East Anglia TWO Offshore Windfarm

Appendix 17.1

Infrastructure and Other Users Consultation Responses

Applicant: East Anglia TWO Limited
Document Reference: 6.3.17.1
SPR Reference: EA2-DWF-ENV-REP-IBR-000909_001 Rev 01
Pursuant to APFP Regulation: 5(2)(a)

Drg No	EA2-DWF-ENV-REP-IBR-000920		
Rev	3	Datum: WGS 1984	
Date	30/08/19	Projection: Zone 31N	
Figure	28.21c

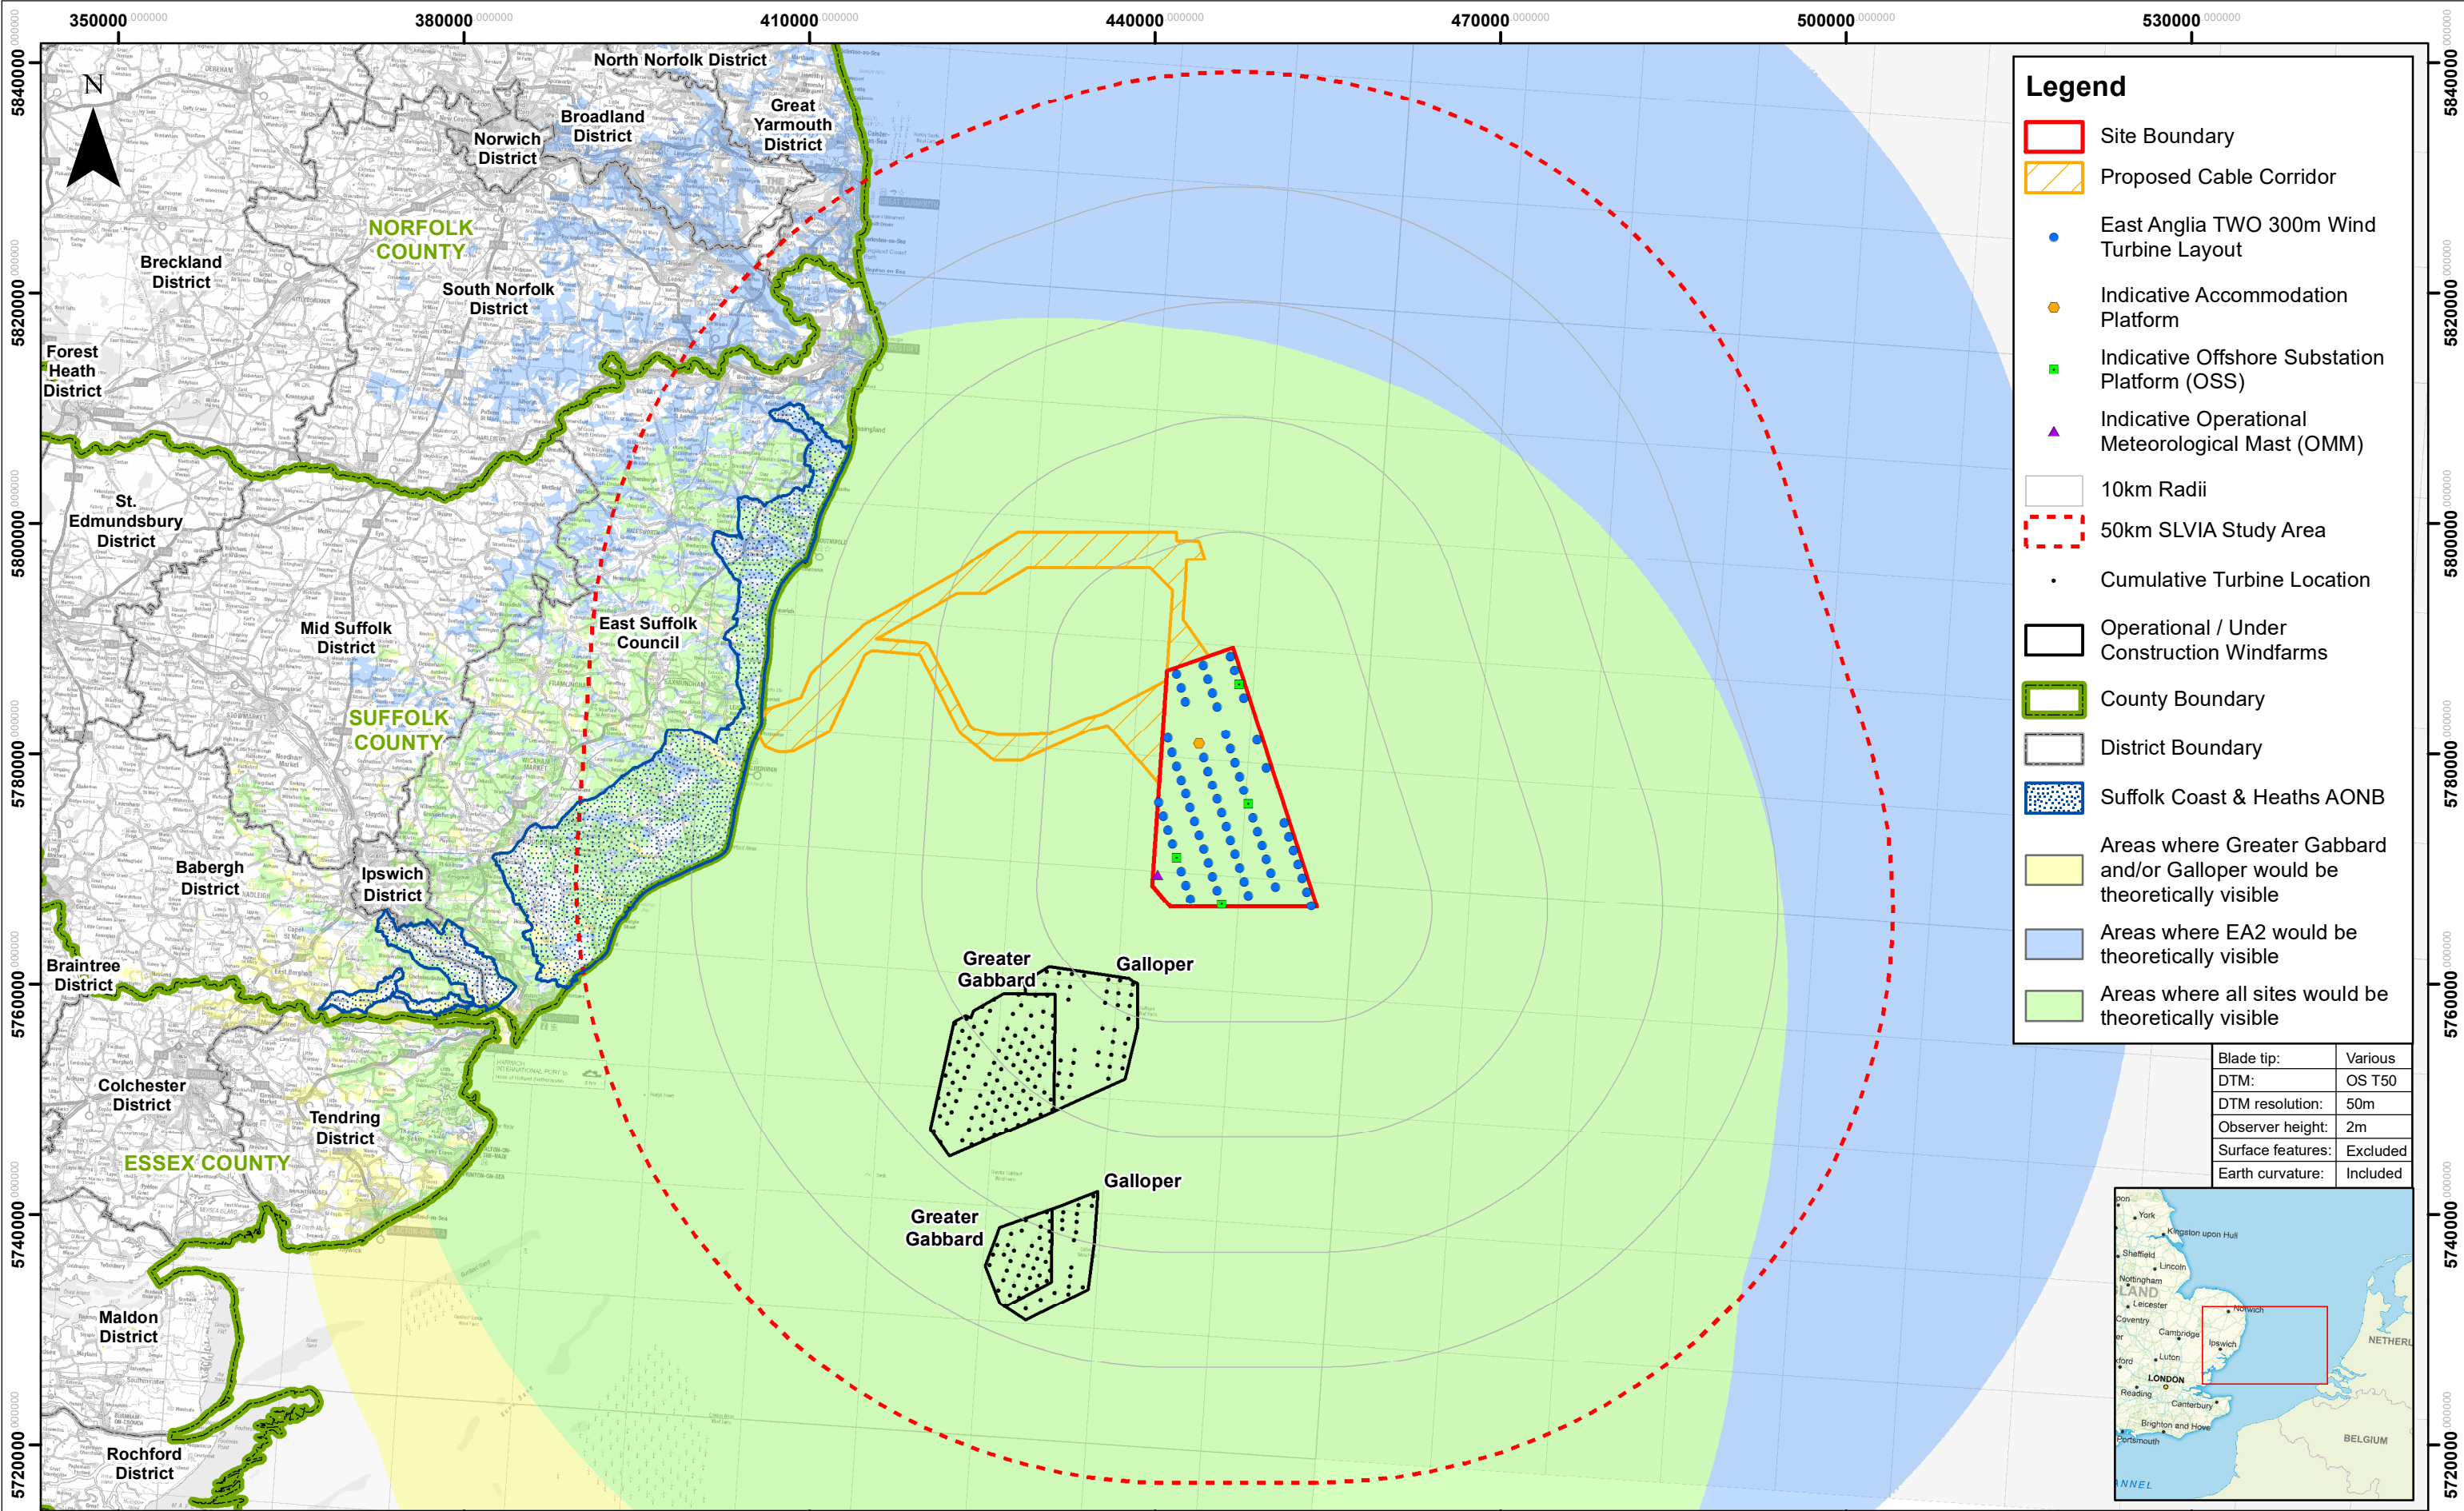
Galloper Wind Farm Ltd. (GWFL)	19/12/2017 Scoping Response	To protect GWF assets, GWFL requires the following constraints to be built into both projects; SPR to maintain a minimum 50m separation between EA2 cables and the GWFL and Gabbard cables at the landfall where the cables are buried due to thermal constraints; GWFL requires 10m either side of the GWF onshore cables for access for maintenance and repair; GWFL requests that technical as built information is made available and delivered indicating cable design, trench design, GPS co-ordinates of assets, and nomenclature etc. GWFL will reciprocate and provide this information when available for the Galloper assets.	Discussions of crossing agreements have commenced and will continue throughout application, examination and post consent. A crossing agreement will be sought from Galloper Windfarm Limited (GWFL). Further work has been undertaken since Scoping to refine the landfall location. These changes now ensure that the GWFL cables are only crossed once (see Chapter 4 Site Selection and Alternatives)

GWFL	19/12/2017 Scoping Response	The scoping proposals show cables will cross offshore. However, the location of the NGET substation is not named, and could potentially be in or around Leiston in the vicinity of GWFL assets. GWFL requests that the cable routes associated with both projects are designed such that the need to cross GWFL cables twice is absolutely avoided.

Consultee	Date / Document	Comment	Response / where addressed in the PEI
GWFL	19/12/2017 Scoping Response	The position of any beach or sea anchors should also be considered in relation to the proximity of the GWFL cables. GWFL must be consulted on any beach or sea anchor that is placed within 300m of the GWF export cable.	
GWFL	19/12/2017 Scoping Response	There is one AoS for a shared offshore cable export route to EA1N and EA2. The figure shows that the EA cables will cross the Galloper cables within 10km of the shore. GWFL expects a formal cable crossing agreement between GWFL and applicable projects to be in place in advance of the DCO application being submitted. GWFL would welcome early consultation including the review of method statements in relation to this.	
Interoute	14/02/2018	Consultation with Interoute in relation to crossing and proximity agreements in relation to the Concerto Seg-S. Interoute provided information on the location and installation of the Concerto Seg-S cable to help inform the East Anglia TWO export cable development process.	Proximity and crossing agreements are currently being drafted for agreement with Interoute. Potential impacts upon sub-sea cables are discussed in section 17.6 of this chapter.

Greater Gabbard Offshore Wind Ltd (GGOWL)	26/03/2019 Section 42 response	SPR must demonstrate that any development proposals will not impact on the integrity and stability of GGOWL's infrastructure	Chapter 4 Site Selection and Assessment of Alternatives and Chapter 6 Project Description demonstrate how other infrastructure constraints have been considered in the design of the project. Potential impacts with cables from Greater Gabbard are assessed discussed in section 17.6 of this chapter.
GGOWL	26/03/2019 Section 42 response	GGOWL requires that SPR provide site layouts inclusive of wind turbine generator details and positions when available. This is to enable GGOWL to assess whether there will be any potential wake effects on Gabbard wind farm. If any concerns	The full response will be used to inform the proximity agreements with Greater Gabbard at the detailed design phase.

Coralline Crag

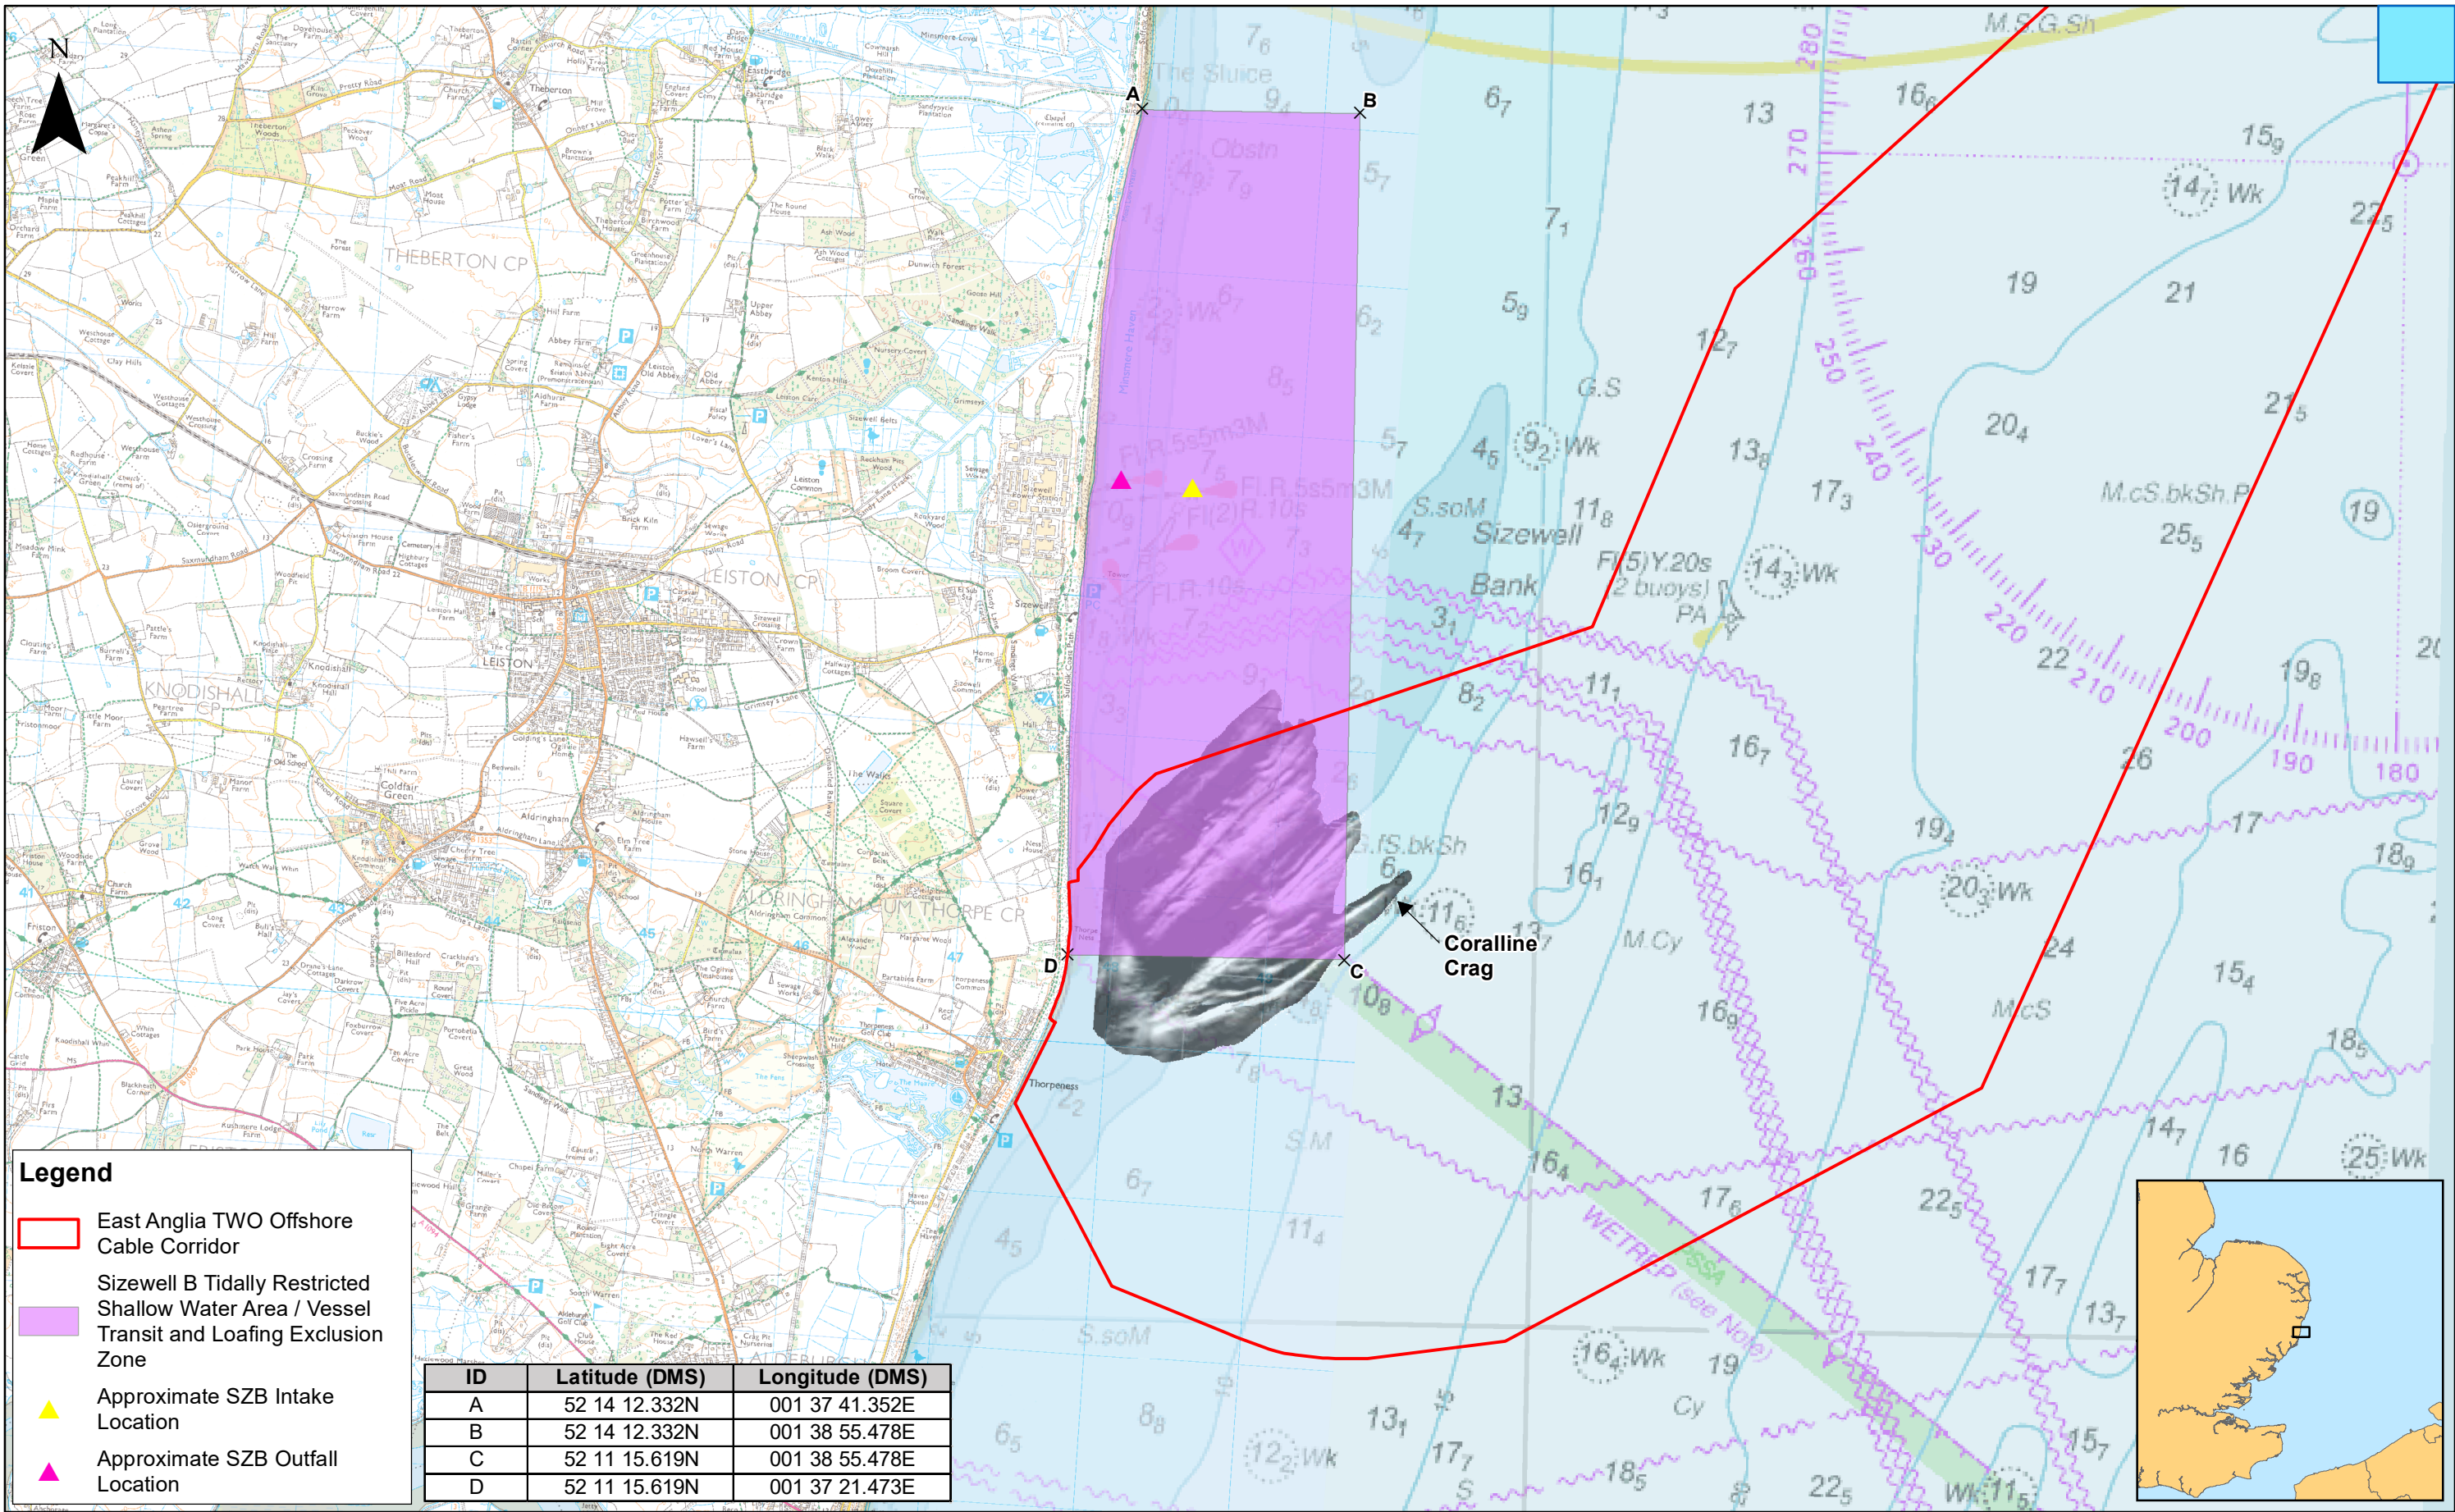
The following comments were made in response to the PEIR and were taken into account in the production of this ES.			
EDF Energy	26/03/2019 Section 42 consultation response	Any development offshore, as ScottishPower Renewables need to demonstrate that physical compatibility of its projects would have no adverse effects on the future operations of Sizewell C. This needs careful investigation prior to submission of the applications. We would like to work with you to understand any potential impacts and develop a way forward that would not impact Sizewell C.	As outlined in sections 4.7.4.1.3 and 4.7.4.2.2 of Chapter 4 Site Selection and illustrated in Figure 4.3 , EDF Energy raised concerns in relation to potential impacts to an important geological formation (Coralline Crag) in the landfall area which resulted in the Applicant widening the offshore cable route to the south so that this formation could be avoided. Furthermore, an assessment of the offshore cable corridor and landfall selection (see Appendix 4.6), using

Consultee	Date / Document	Comment	Response / where addressed in the PEI
			<p>information provided by EDF was undertaken to investigate construction methodologies which would avoid physical impacts to the Coralline Crag. This study is summarised in section 4.8.2 of Chapter 4 Site Selection and the results were used to inform landfall and nearshore engineering decisions which required refinement of the offshore cable corridor in the nearshore area.</p> <p>It is likely that the HDD pop-out location will be to the south of the outcrop of Coralline Crag (see section 17.6.1.2 of this chapter and section 7.6.2.7 of Chapter 7 Marine Geology, Oceanography and Physical Processes). Hence, there will be no interruption of the circulatory sediment transport pathways between the coast and Sizewell Bank.</p>
Verizon	26/03/2019 Section 42 response	The installation of the windfarm with associated turbines, array and export cables may represent a serious risk to our asset, the Ulysses 2 telecommunications cable, and we request a crossing and proximity agreement be negotiated in good faith between Scottish Power and Verizon should Verizon deem it necessary	Discussions between the Applicant and Verizon will continue post application and an appropriate cable crossing agreement will be reached.
